CITY OF PORTLAND

May 15, 2000

RE: 428 Fore St.
CBL: 032-R-001

STAIR B (1 HOUR ENCLOSURE)

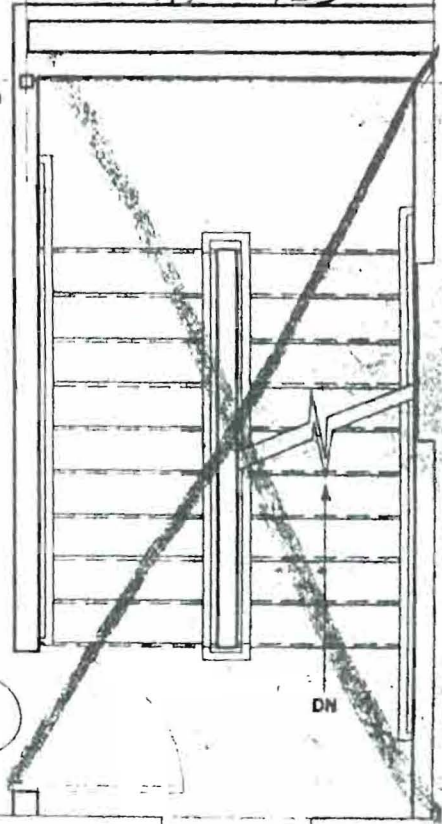
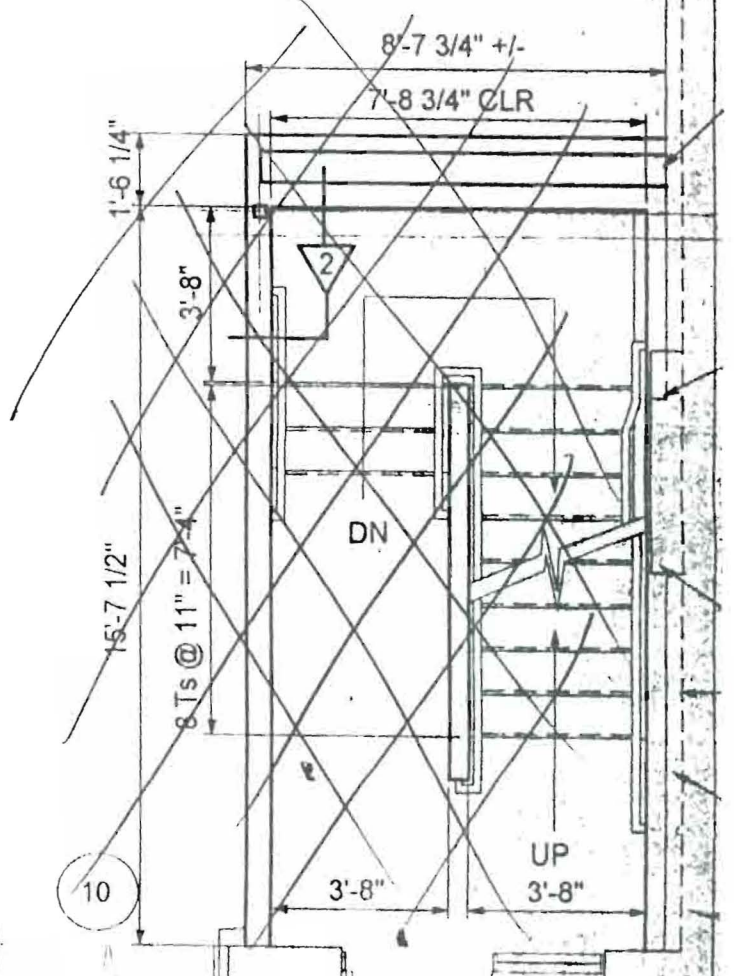
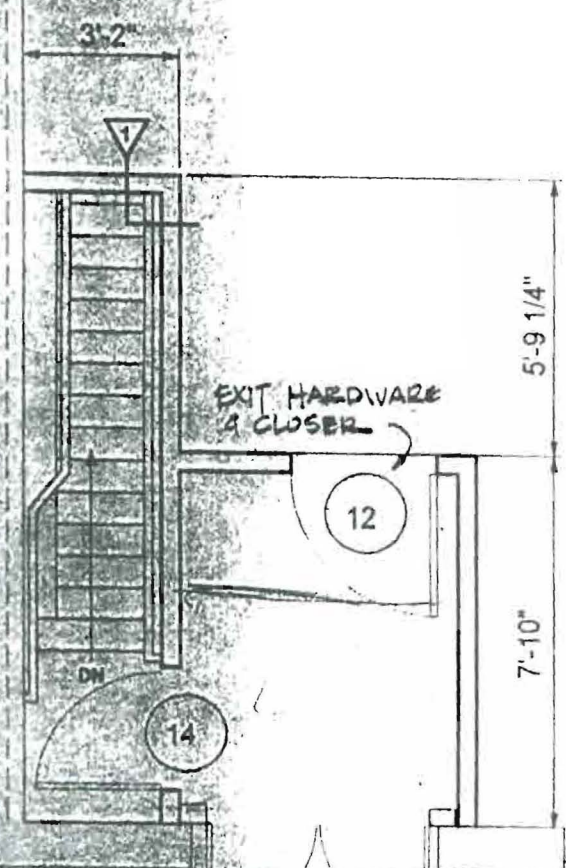
This is to verify that the Interior stairway enclosure at 428 Fore St. needs to comply with the BOCA 1996 Building Code 1014.11 regarding fire separation assemblies.
